# CITY OF ALBUQUERQUE

April 4, 2022

**Re: Presidential Cultivation FAC  
9910 Acoma RD SE  
Traffic Circulation Layout  
Architect's Stamp 03-01-2022 (L20-D076)**

CIVIL101

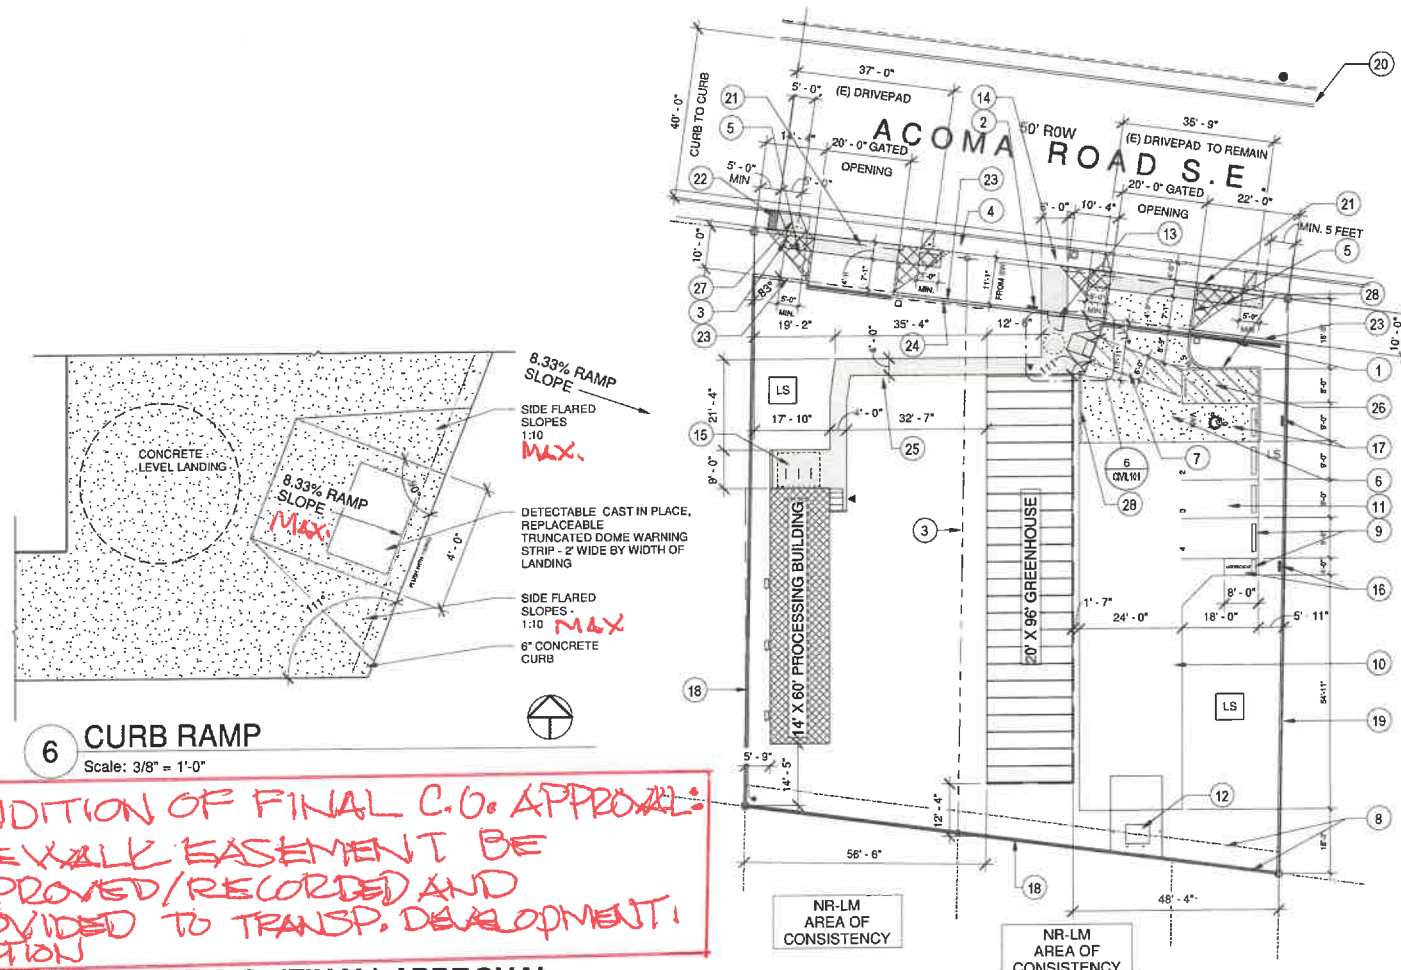
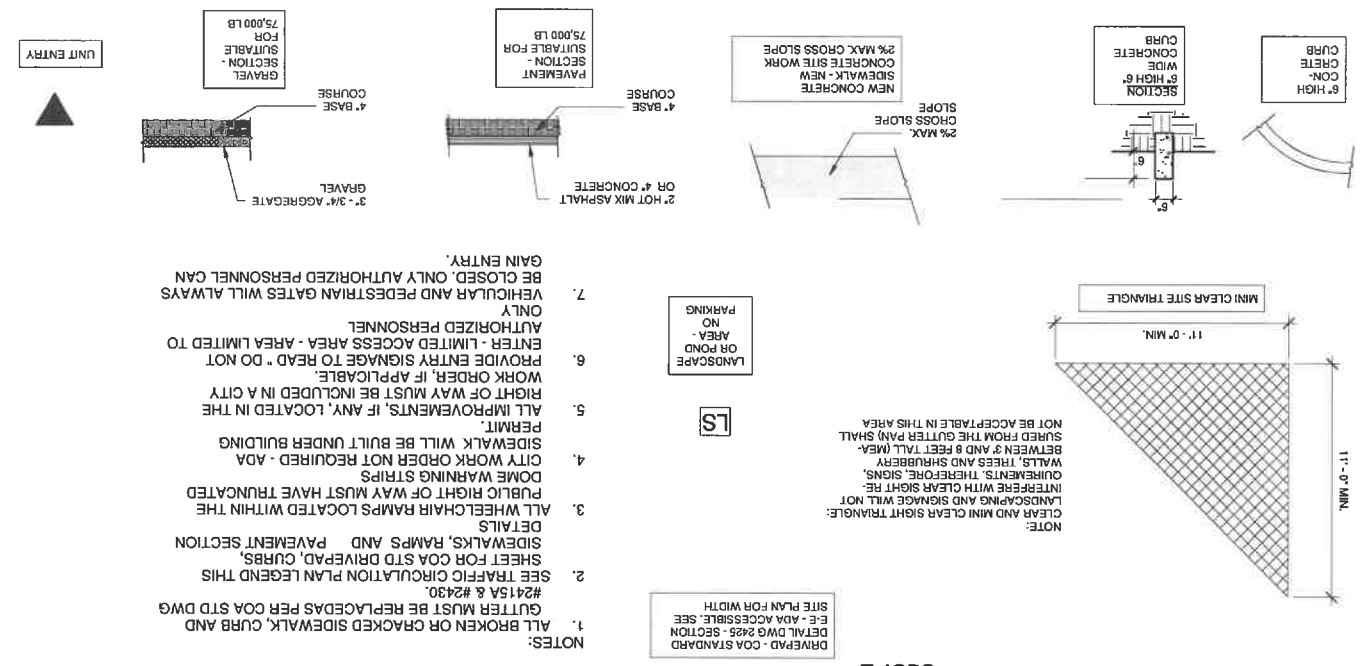
1. Listed are the number of parking spaces required by the IDO as well as the proposed number of parking spaces including bicycle and motorcycle parking.  
**Coordinate/discuss with Zoning.**
2. Your ADA pathway and sidewalk culvert might be in conflict. Please address this concern.
3. **Key Note 7:** Paint pavement markings white not yellow.
4. **Keyed Note 9:** Provide detail.
5. **Keyed Note 13:** Gate must be 6 ft in width.
6. **Keyed Note 21:** You will need sidewalk easements for pathway outside of COA ROW.
7. Clarify the extents of the current phase. Provide a phasing plan.
8. Identify the right of way width, medians, curb cuts, and **street widths** on **ACOMA ROAD**.
9. **Maximum access width for** arterial, collector, and **local streets(PARKING LOT)** are as follows:

10. The ADA access aisles shall have the words **"NO PARKING"** in capital letters, each of which shall be at least one foot high and at least two inches wide, placed at the rear of the

parking space so as to be close to where an adjacent vehicle's rear tire would be placed. (66-1-4.1.B NMSA 1978). **Provide pavement marking detail for text.**

11. **ADA curb ramp (on site):** Provide side flare slopes.
12. **Motorcycle parking spaces (If applicable):** Label pavement MC.
13. Curbing should be installed to delineate landscape, parking, and pedestrian ways and identify points of access. Please call out detail and location of barrier curb **(If applicable)**.

14. Show the clear sight triangle and add the following note to the plan: "Landscaping and signage will not interfere with clear sight requirements. Therefore, signs, walls, trees, and shrubbery between 3 and 8 feet tall (as measured from the gutter pan) will not be acceptable in the clear sight triangle.

16. Add a note stating "All broken or cracked sidewalk must be replaced with sidewalk and curb & gutter." A build note must be provided referring to the appropriate City Standard drawing (2430 & 2415A).
